DEVELOPMENT REVIEW BOARD--SPEED MEMO

DRB CASE NO/PROJECT NO: 1004875 AGENDA ITEM NO: 6
	SUBJECT:
	Site Plan for BP Final Plat Preliminary Plat
	ACTION REQUESTED:
P.O. Box 1293	REV/CMT:() APP:(x) SIGN-OFF:() EXTN:() AMEND:()
Albuquerque	ENGINEERING COMMENTS:
	An approved Subdivision Improvements Agreement with financial guarantees is required for Site Development Plan sign-off.
New Mexico 87103	
vww.cabq.gov	RESOLUTION:
	APPROVED; DENIED; DEFERRED; COMMENTS PROVIDED; WITHDRAWN
	SIGNED-OFF: (SEC-PLN) (SP-SUB) (SP-BP) (FP) BY: (UD) (CE) (TRANS) (PKS) (PLNG)
	DELEGATED: (SEC-PLN) (SP-SUB) (SP-BP) (FP) TO: (UD) (CE) (TRANS) (PKS) (LNG)
	FOR:
	SIGNED: Bradley L. Bingham City Engineer/AMAFCA Designee 924-3986 DATE: December 19, 2007

DRB CASE NO/PROJECT NO: 1004875 AGENDA ITEM NO: 6

Project #1004875, Religious Society of Friends-Quaker Church

PLAT OF
LOT 19-A
BLOCK 2
IVES ADDITION

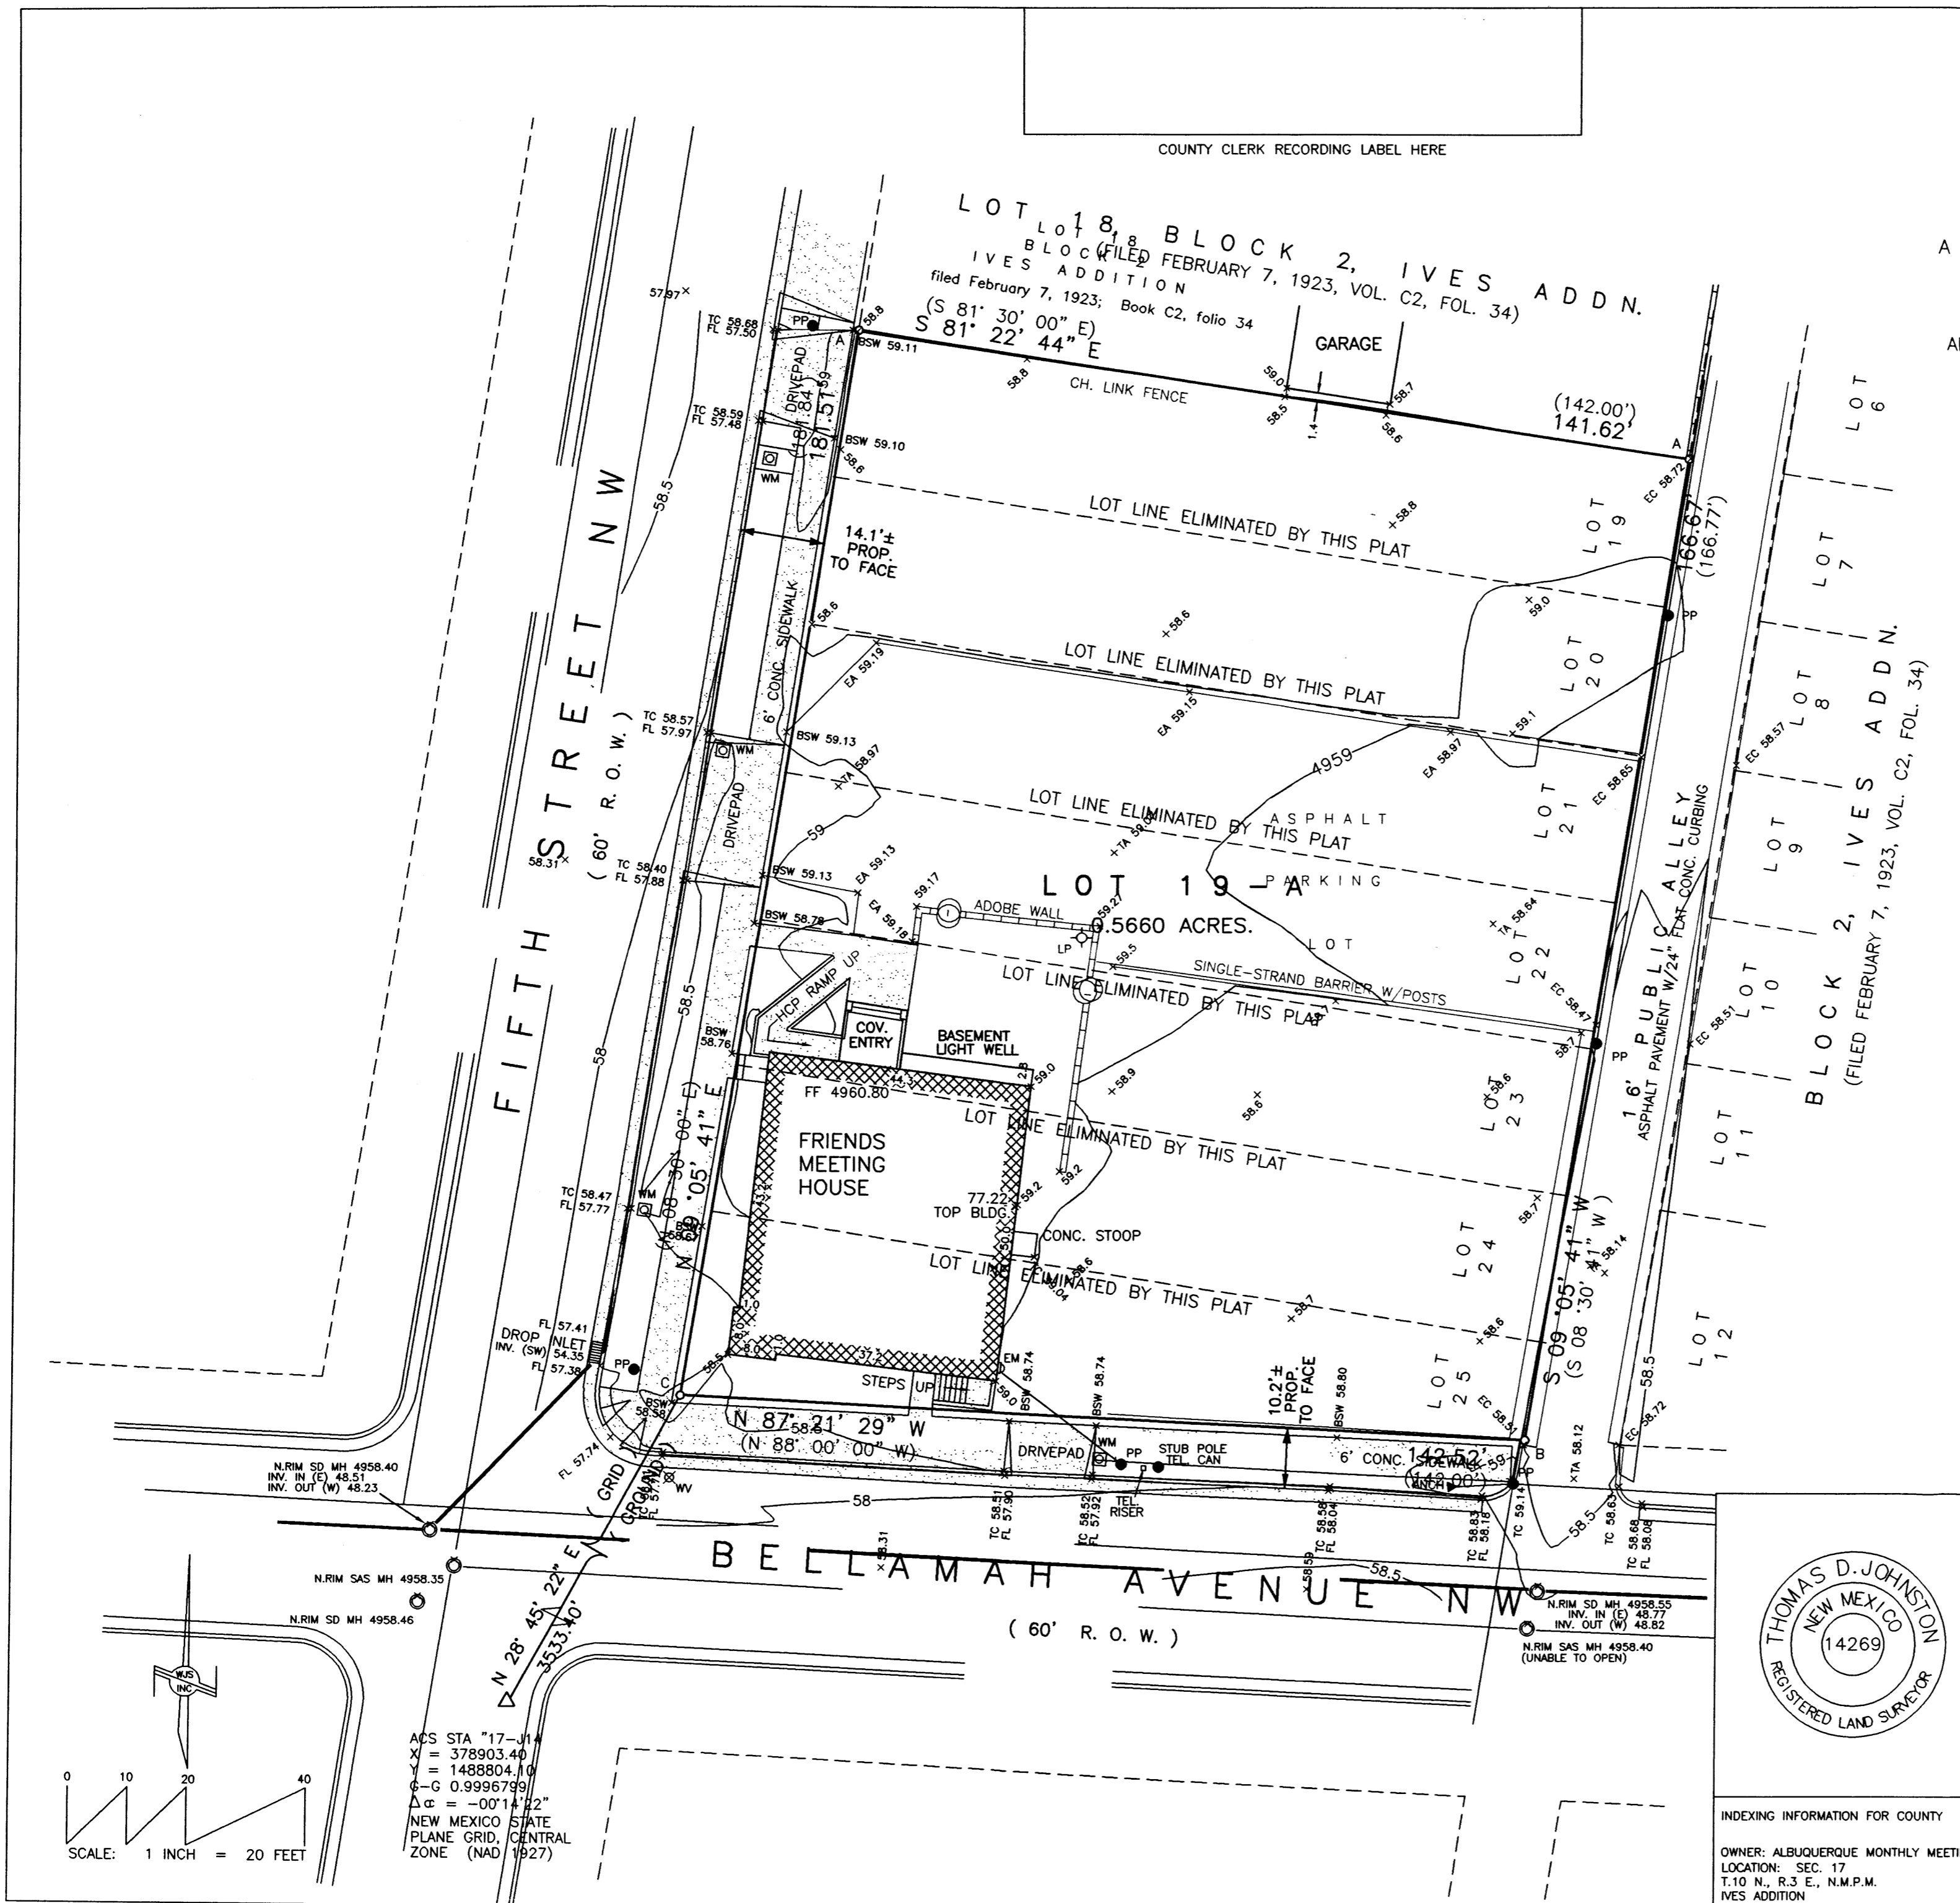
The site plan shows an additional 4 foot of right of way dedication; this must be shown on the plat

Per the Development Process Manual, Table 23.3.3, the right of way at the intersection of a minor arterial

- 6. Additional 4' right of way dedication for alley is shown.
- 7. Intersection right of way is addressed by Wayjohn Surveying plat.
- 8. Infrastructure list provided by Wayjohn Surveying.
- 9. Widths of all existing and proposed driveways are shown on C101.
- 10. References to appropriate City Standard Drawings are provided for all work proposed within the City right of way on drawing A7/C101.

A2 PROPOSED LANDSCAPE PLAN
1"=10'-0"

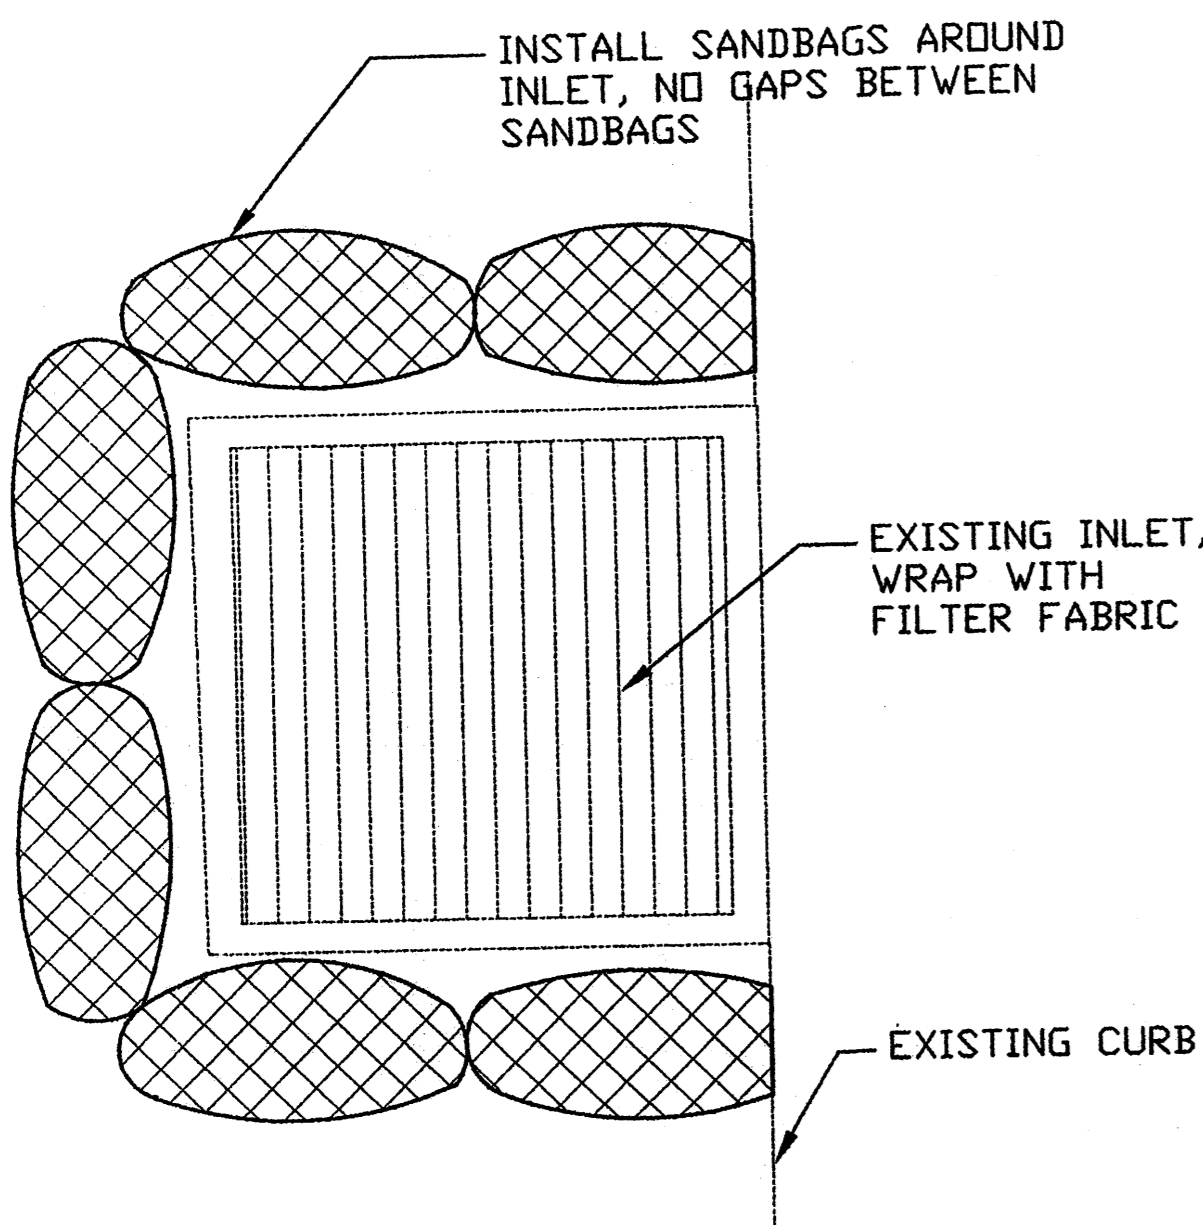
It appears that *all* of the Russian Sage has been replaced with Tuscan Blue Rosemary. The previously used symbol P (for Russian Sage) is no longer there. The condition calls for the replacement of half of the Russian Sage, not all of it.

I added up all the dimensioned landscape beds and keep getting 11,614 square feet, not the 11,898 square feet indicated on the landscaping plan. I am unsure what the discrepancy is, but am noting it here.

- 13. Condition #10. Russian Sage, shown on landscape plan with symbol P, has been added to the plant legend.
- 14. Condition #6B-Note. An error was corrected at one planting area resulting in a total landscaped area of 12,271sf.
